ENG-SF22023-R1-CDs.pdf Markup Summary

[24 sheets total with utility plans]
PCD FILING NO.
PAGE 20-005 (FALCON MEADOWS AT BENT NEIGHBORHOOD REGULATORY PLAN)
PC-20-005 (FALCON MEADOWS AT BENT NEIGHBORHOOD REGULATORY PLAN)

Cursory comments

**STM-LINE A**  
 STA: 0+75 - 2+25  
 SCALE: H: 1"=30' V: 1"=3'

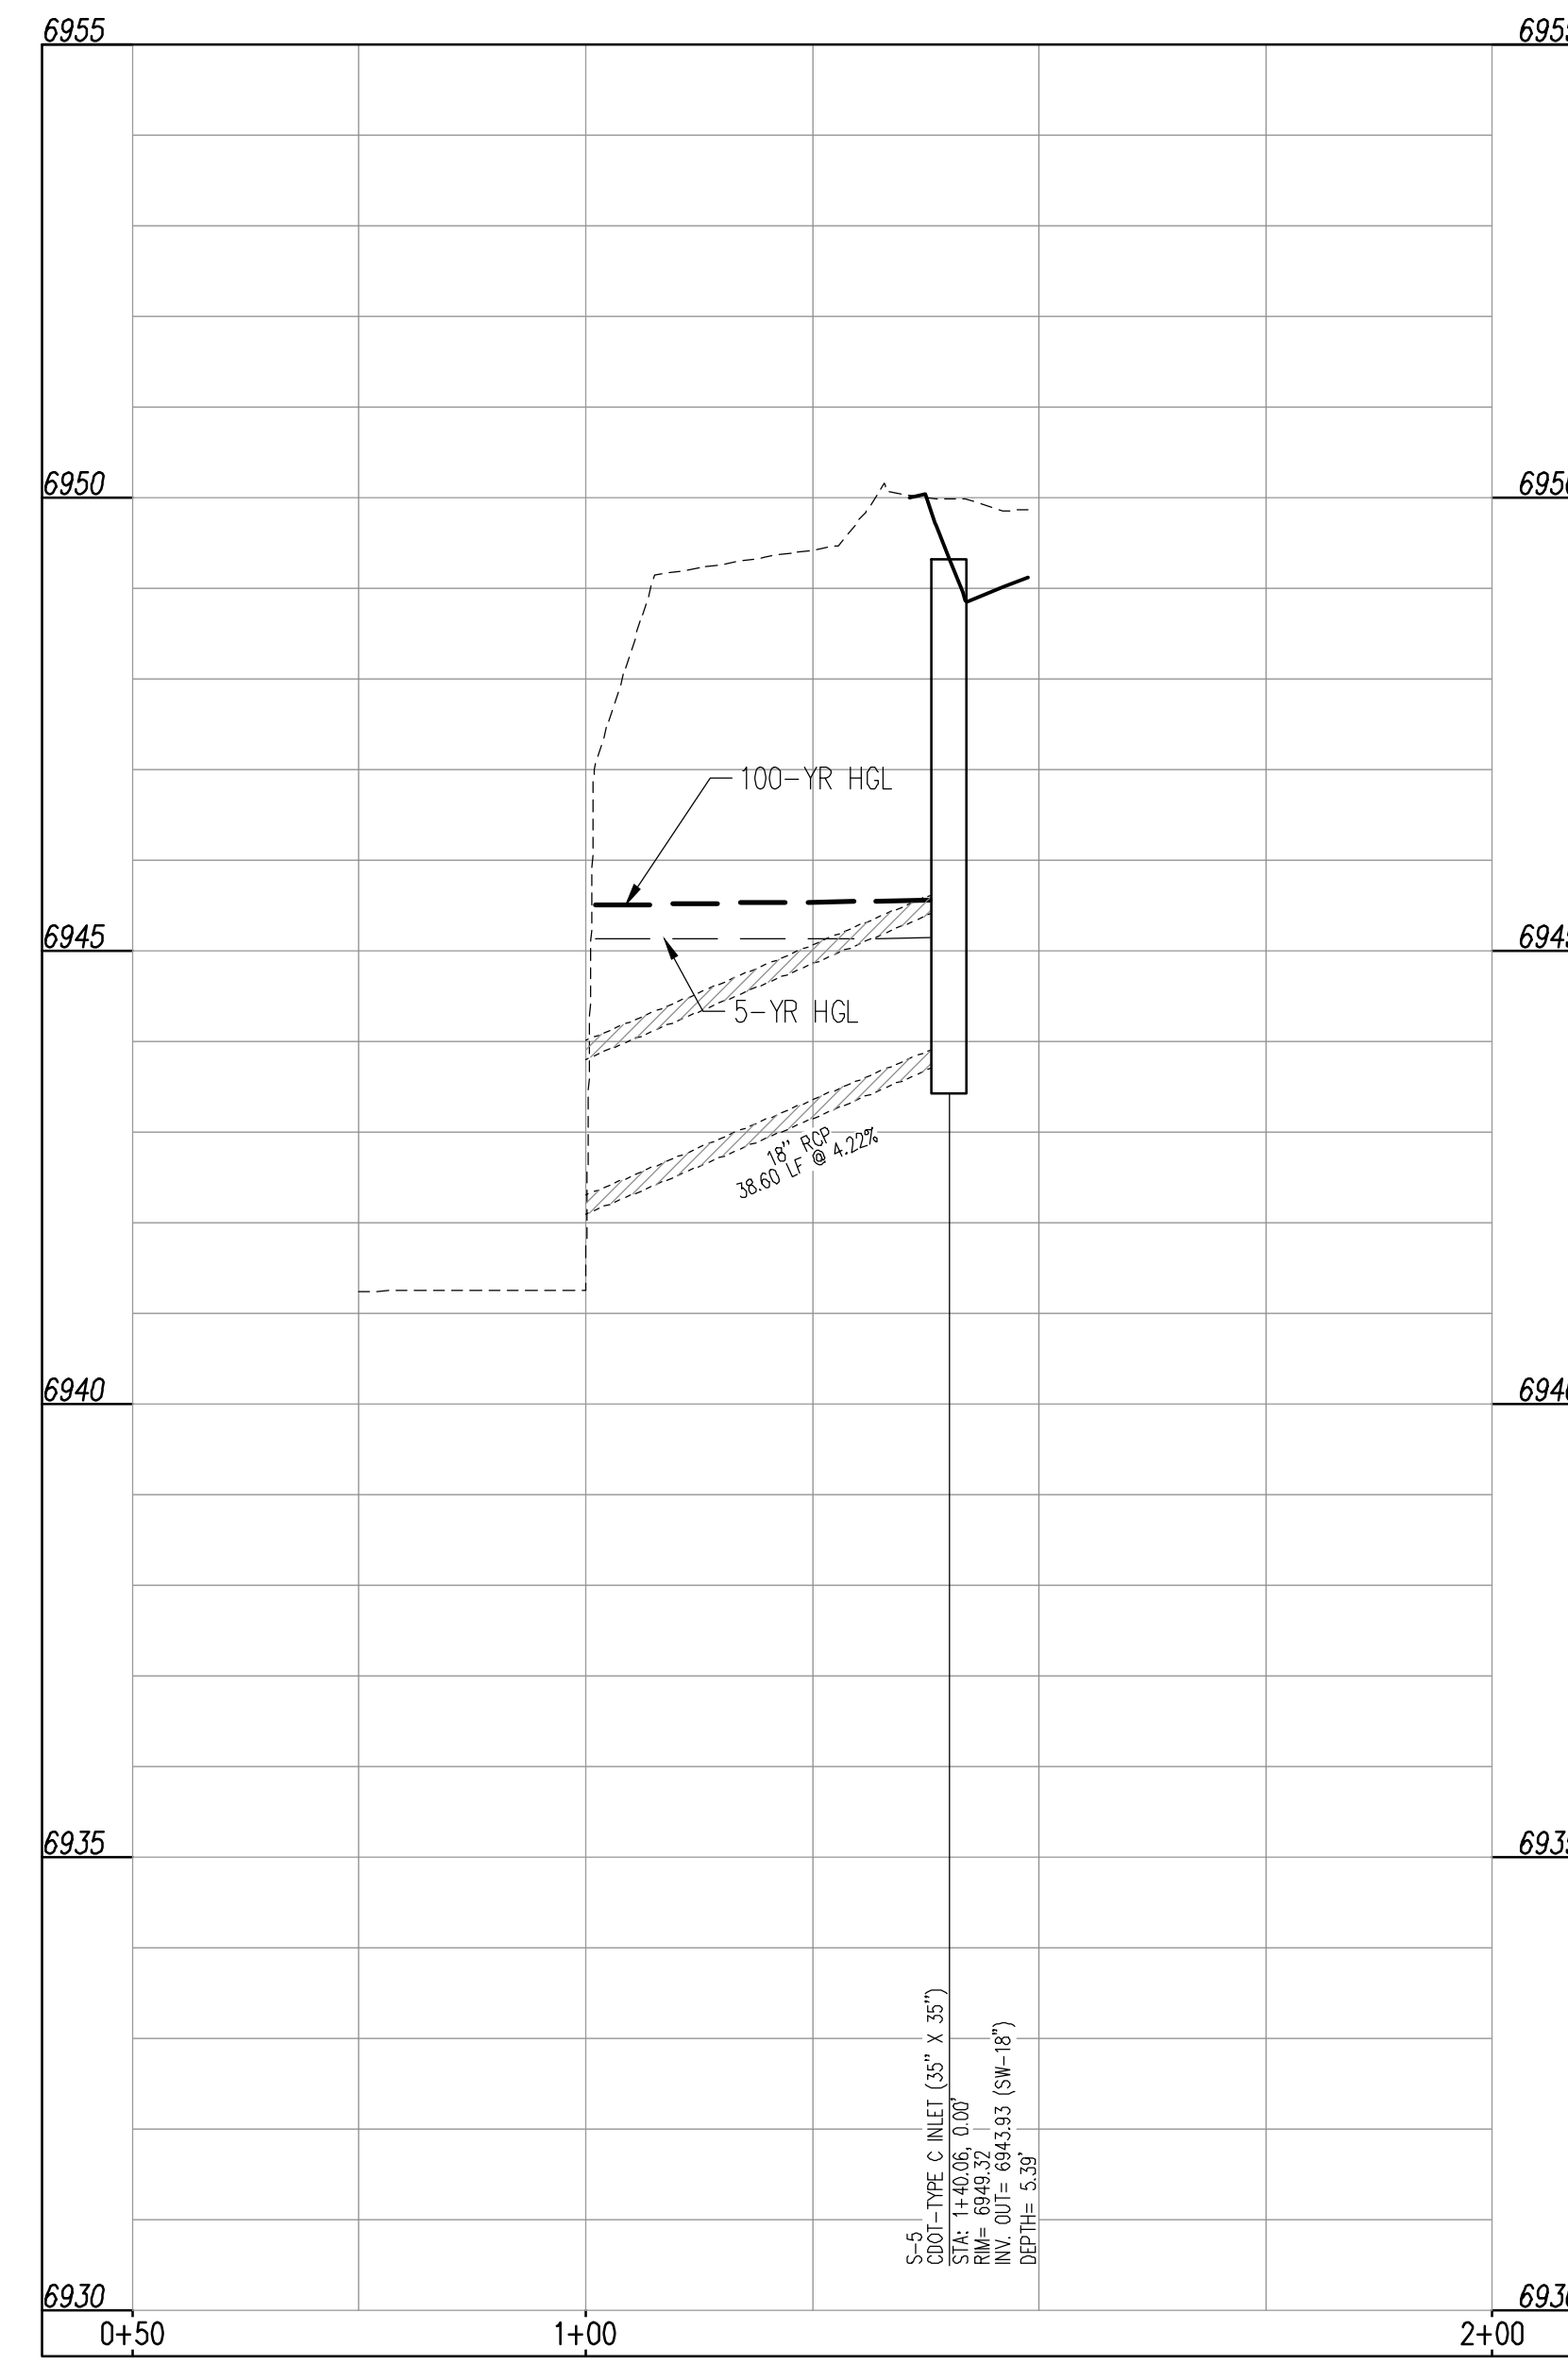
Show and label HGL and Q5 and Q100

Show forebay

**SIGNAGE PLAN**

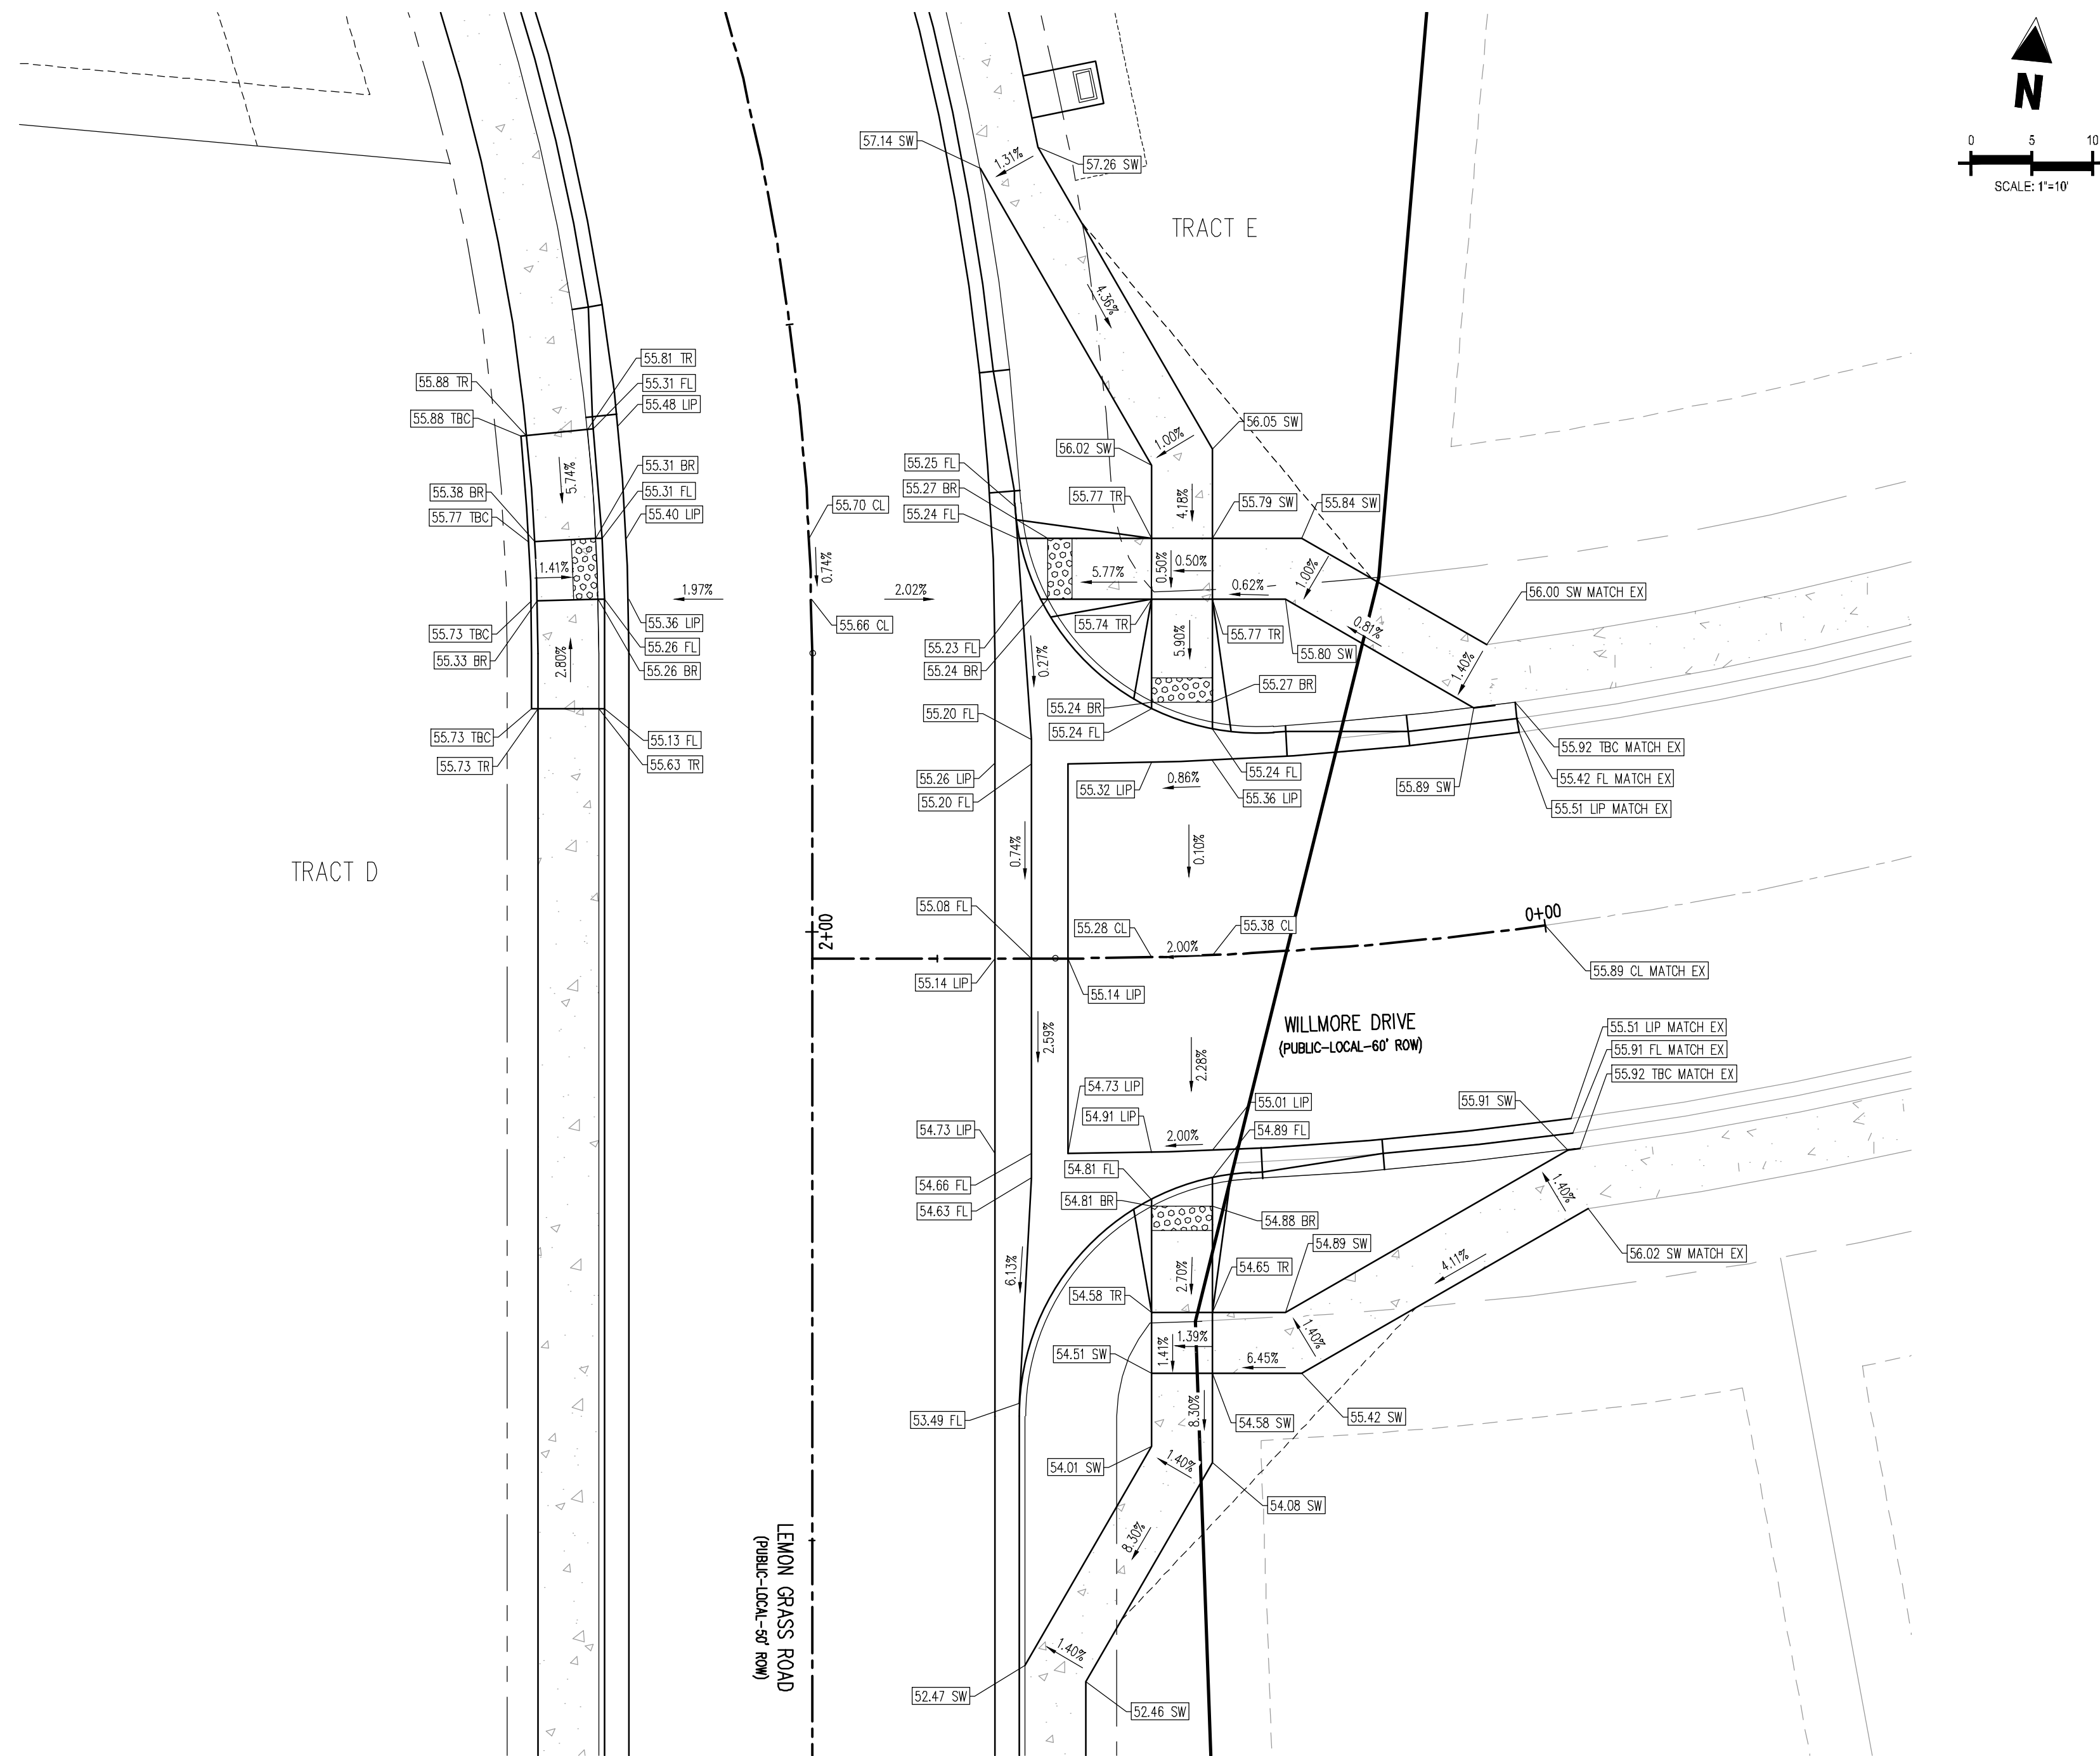
Stop sign?

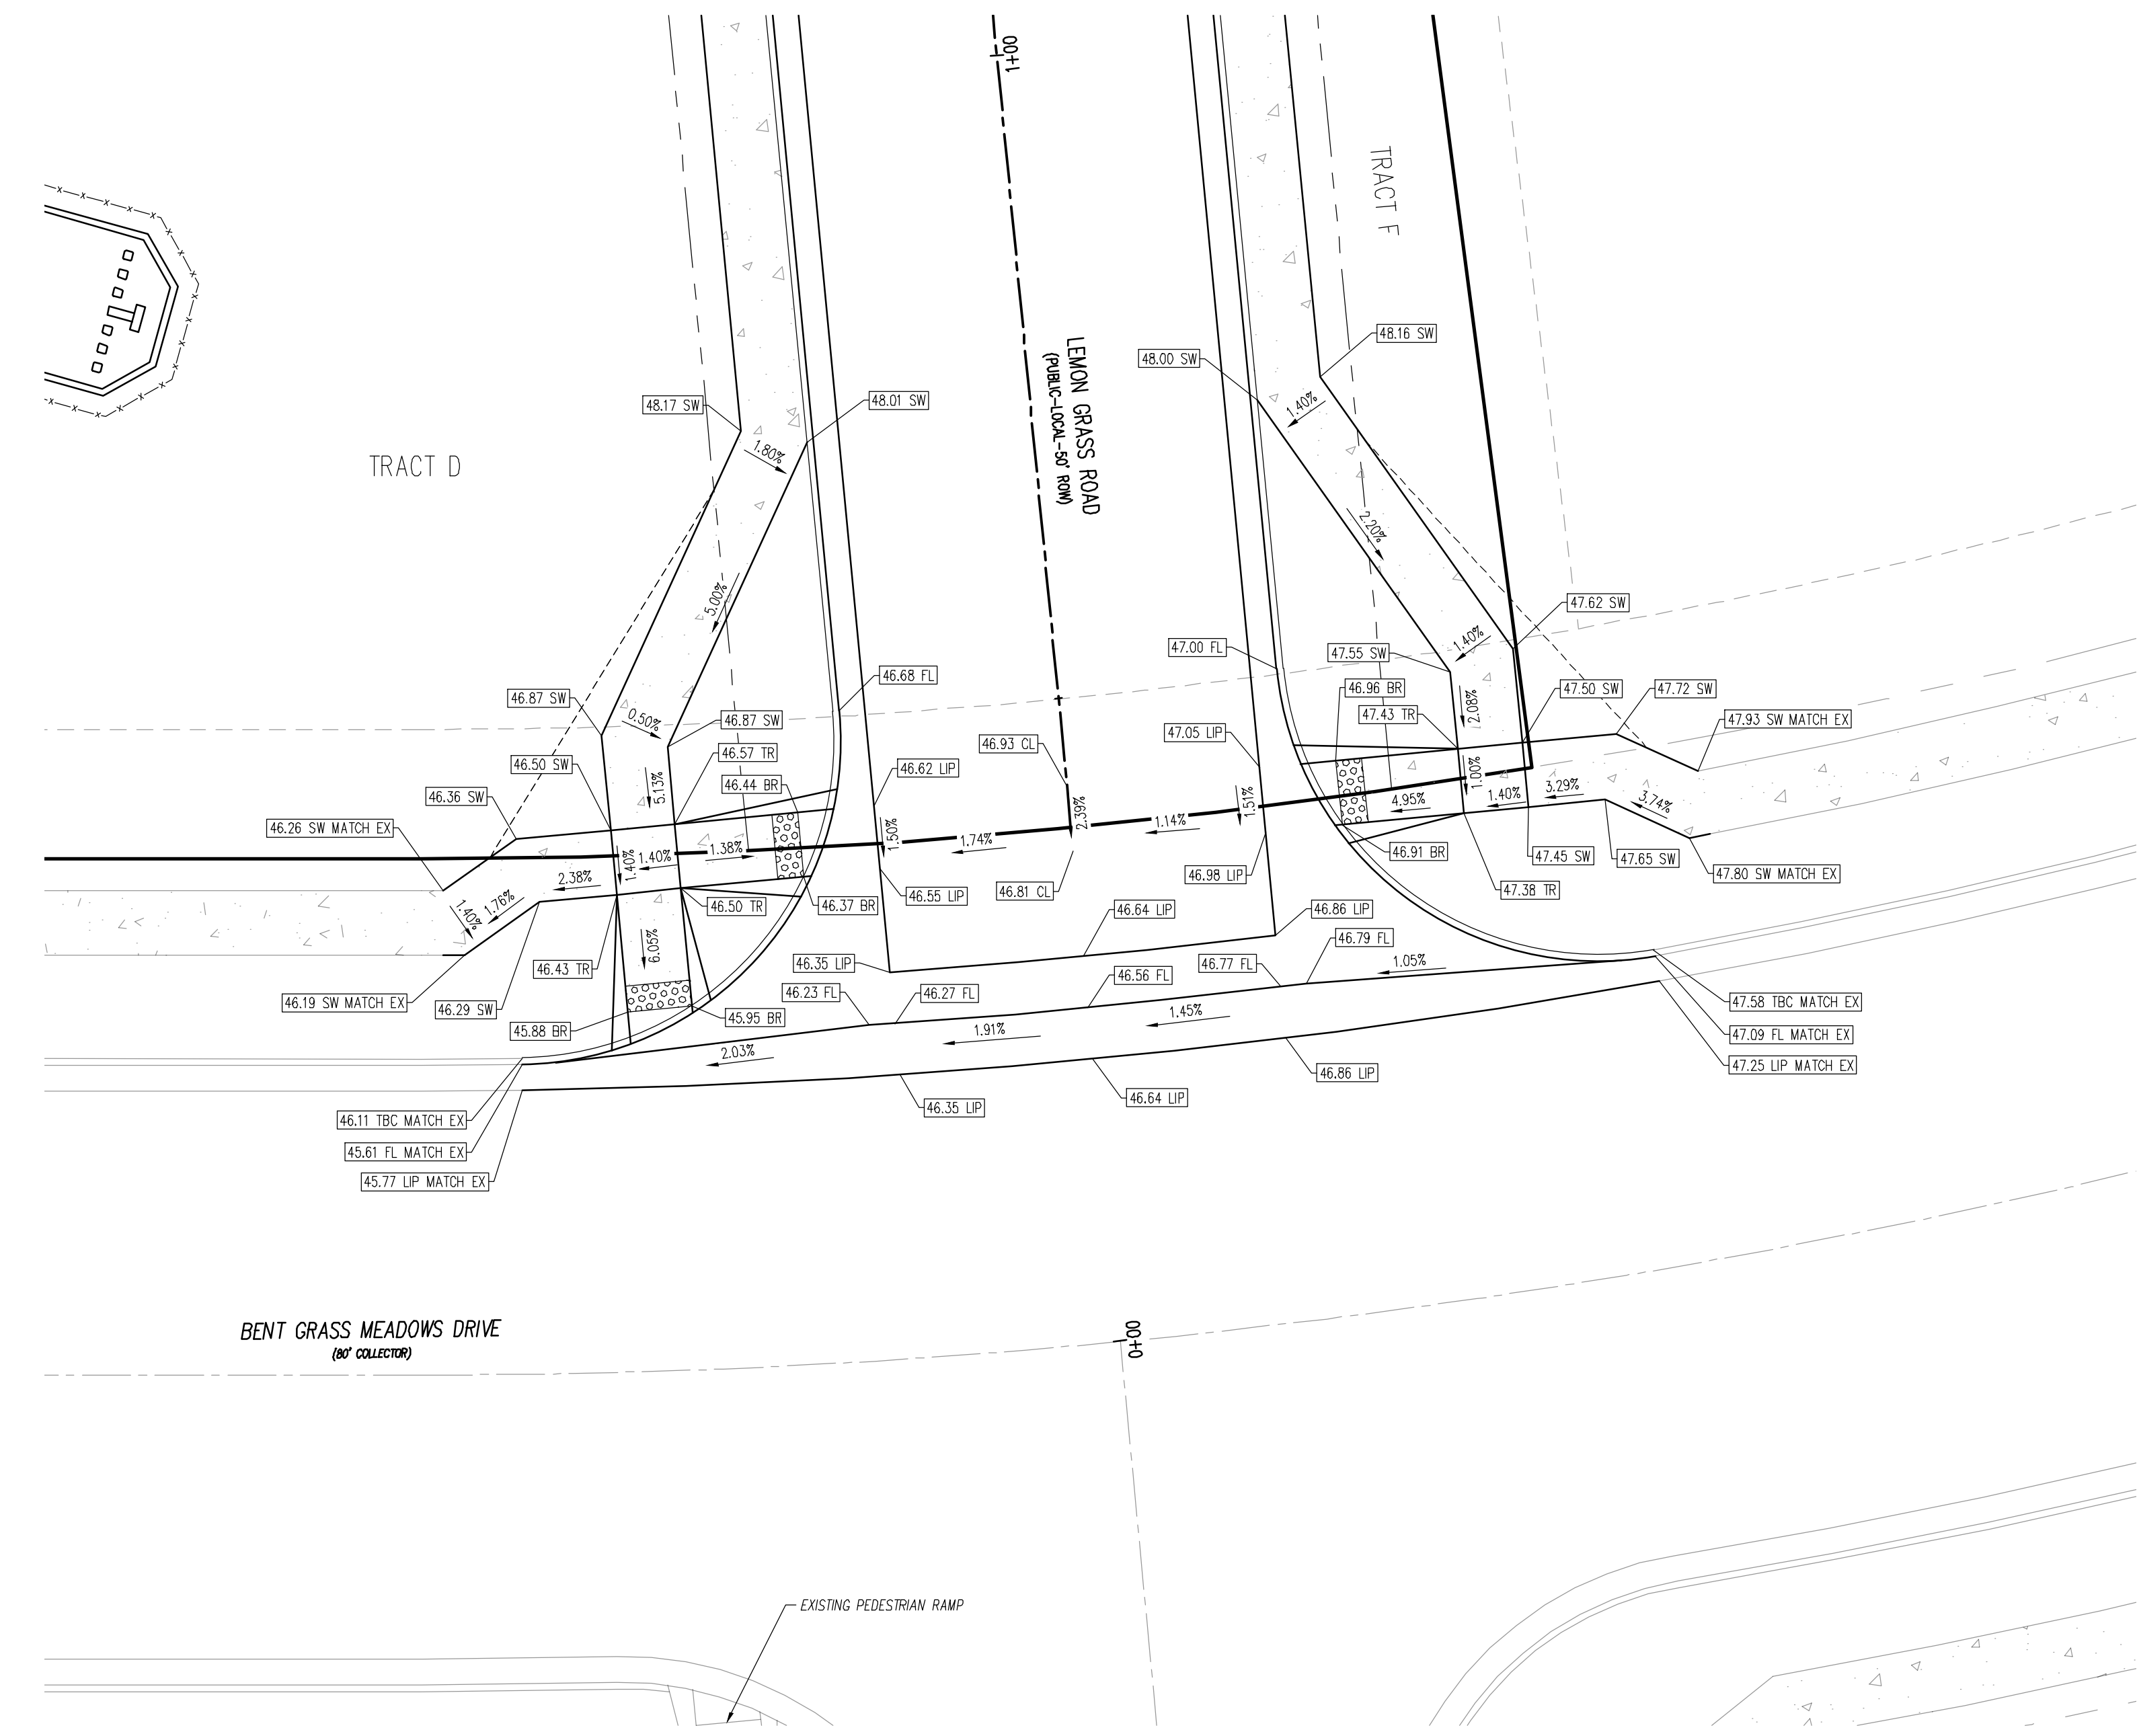
Adjust design per ECM 6.3.1.G
